**2024/0279**

**Address:** 22 Huddersfield Road, Ingbirchworth, Sheffield, S36 7GF

**Description:** Replacement of single storey rear extension with larger single storey rear extension, to 2 storey detached dwelling.

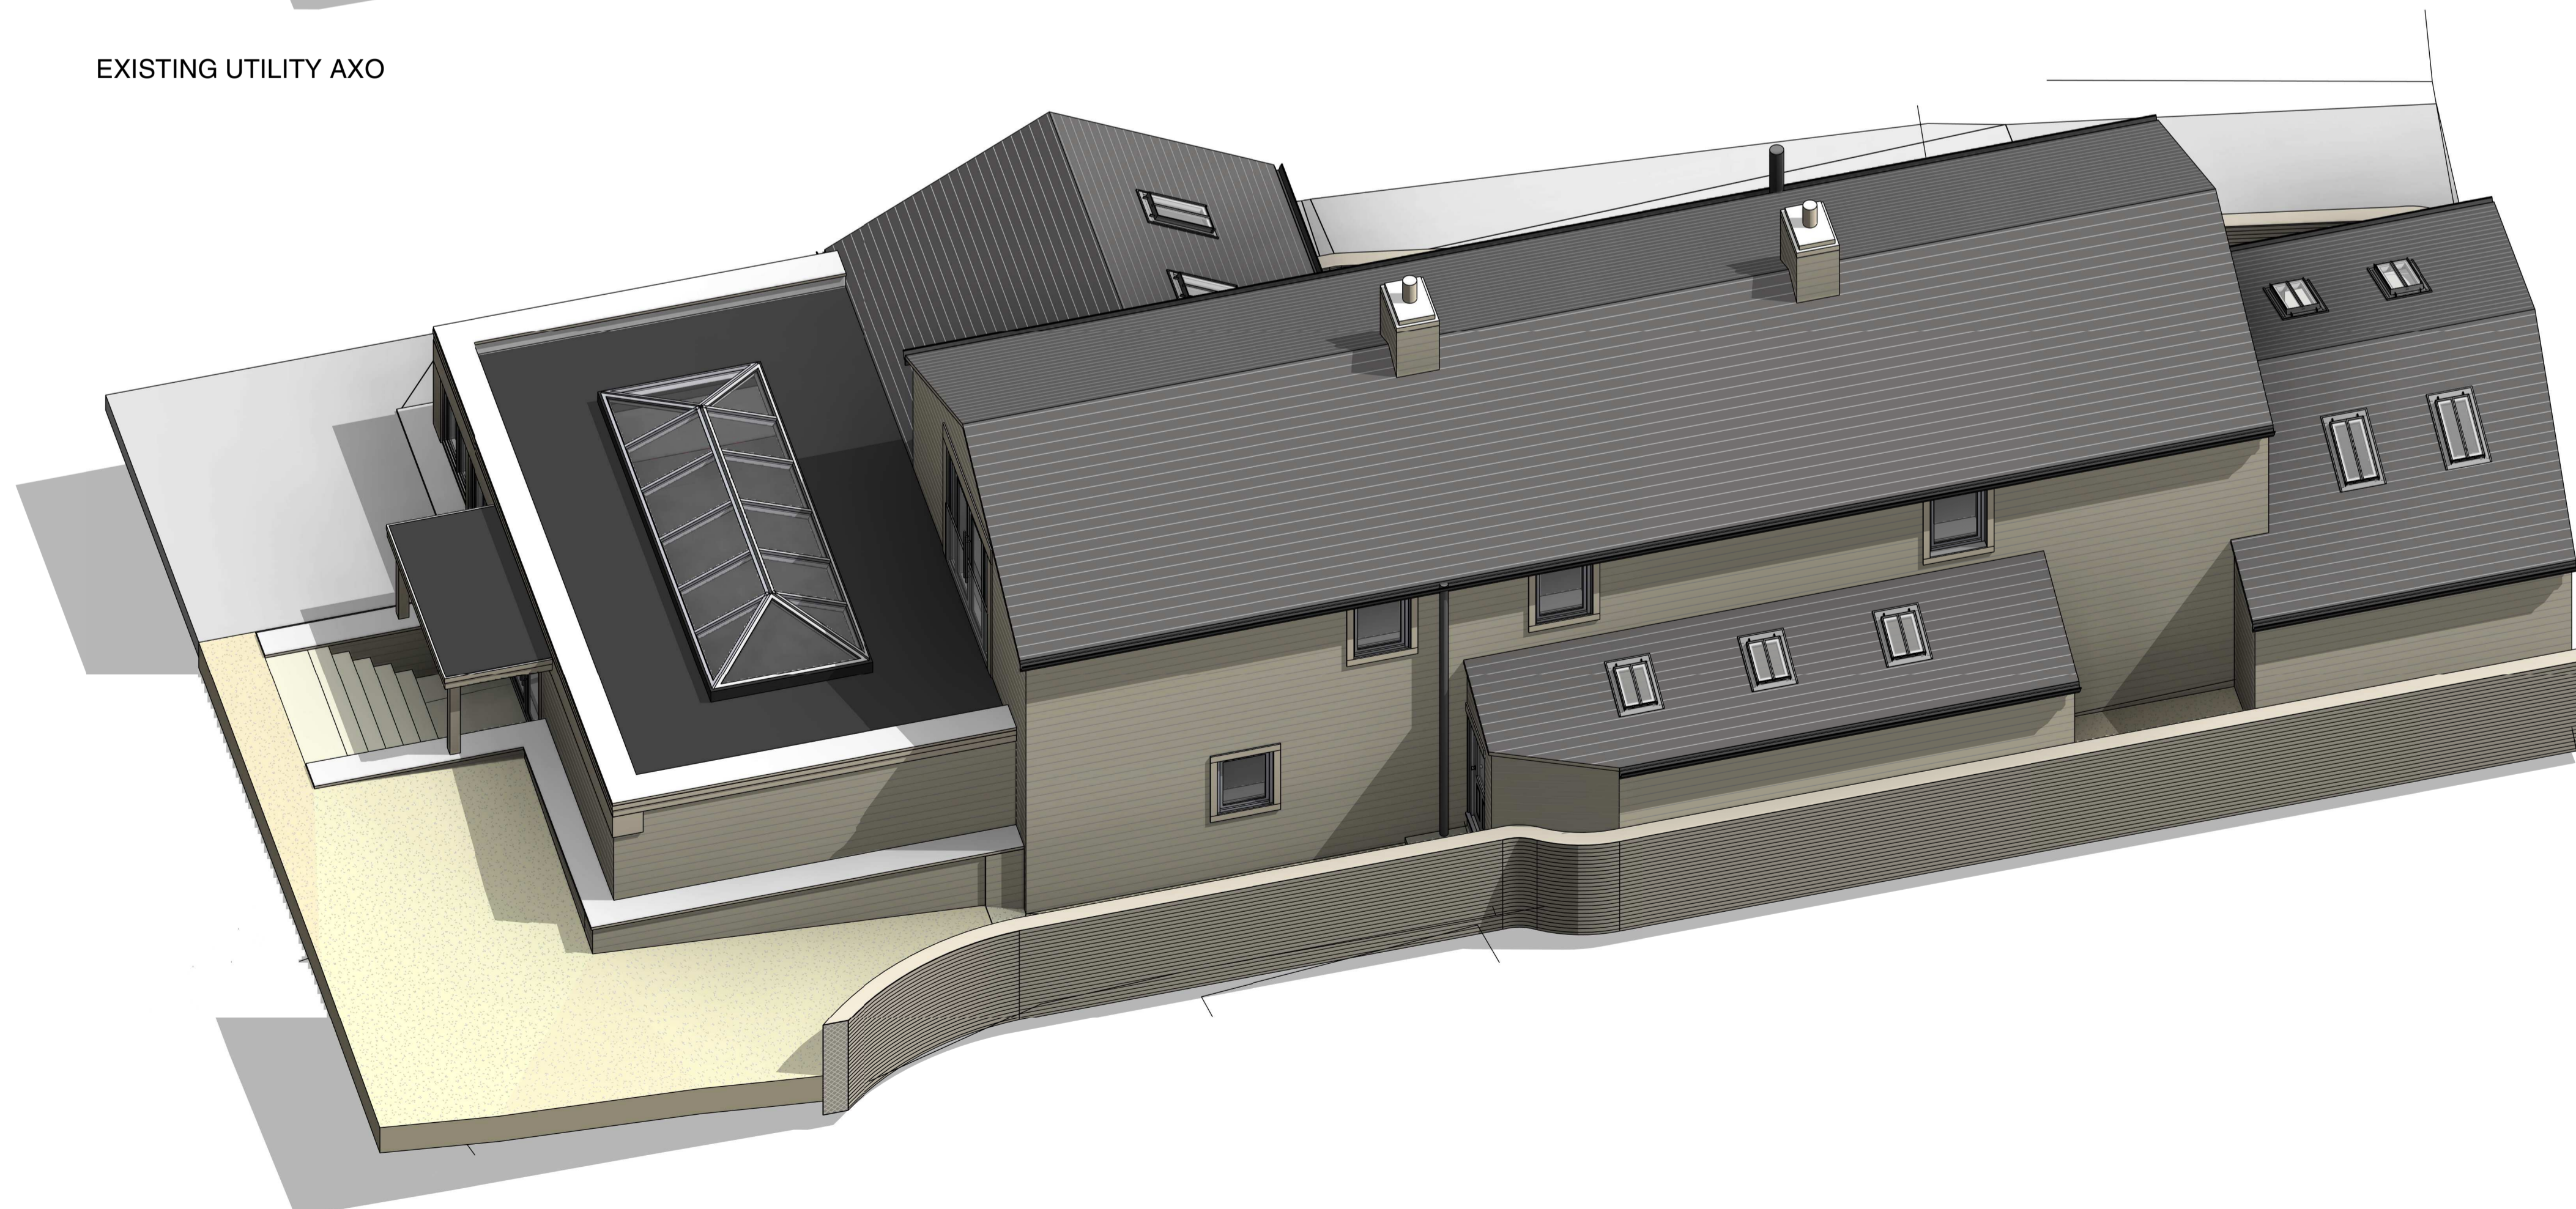
"This application seeks to remove / incorporate the side lean-to utility and double it in length, extending to the north. The new space will have a door at the northern end and incorporate the existing side ground floor window (currently external). This window will be extended down to a threshold to create a new doorway, with three rooflights proposed on the lean-to roof.

Essentially, I have no issues with the proposal as despite being visible is relatively restrained and in-keeping as a design. The loss of the single window is regrettable, but on balance this is only a very minor harm to the setting of the conservation area. Overall, I support the application but would suggest the following conditions:

- The facing stone used in the development shall be natural sandstone, matching the existing in terms of colour, general grain size, type of face dressing, and method of coursing.

- Pointing shall be lime (mix: 1 part NHL 3.5 to 3 parts well graded aggregate or washed river sand) and shall be finished to a slight concave joint of circa 3mm.
- The roof shall utilise tiles that match the existing main roof and shall be laid in diminishing courses.
- Rooflights shall be genuine conservation specification, low in profile, vertically emphasised, with a single vertical divider decorated black.
- Doors and windows shall be timber and shall be recessed in the reveal a minimum of 100mm. “
